From: Plant, Tom - Communities <Tom.Plant@Oxfordshire.gov.uk>
Sent: 20 January 2021 15:38
To: George Smith <George.Smith@Cherwell-DC.gov.uk>
Cc: Transport CDC Minor <Transport.CDCMinor@Oxfordshire.gov.uk>; Planning Consultations - E&E <PlanningConsultations@Oxfordshire.gov.uk>; Cllr George Reynolds <George.Reynolds@Oxfordshire.gov.uk>
Subject: 20/03601/F - West Farm Cottage Main Street Sibford Gower OX15 5RT

Planning application:	20/03601/F
Location:	West Farm Cottage Main Street Sibford Gower OX15 5RT
Description:	Single and two-storey extensions and internal alterations
Type:	Full Development
Case Officer:	George Smith

Client	Mr + Mrs N. Mattinson	
Project	West Farm Cottage Sibford Gower	
Drawing	Site Location Plan	
Date	December 2020	
Scale	1:1250 @ A4	OS Surveys
Job No.	19_076	01
architecture + interiors

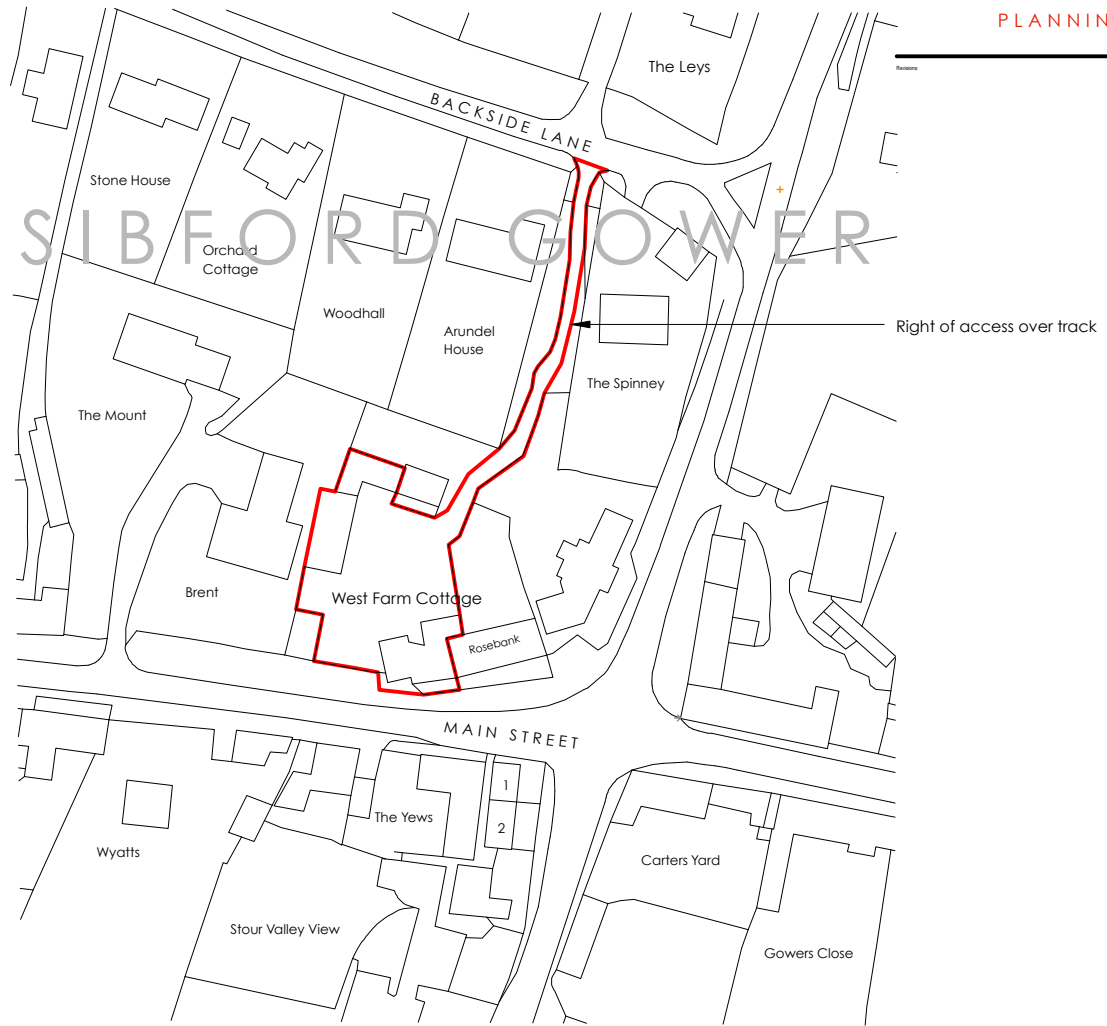
Please note, the redline on the submitted site location plan (drawing 01), does not extend (at the rear) to the adopted public highway. For further details, please see [Oxfordshire County Council Publicly Maintained Highway](#).
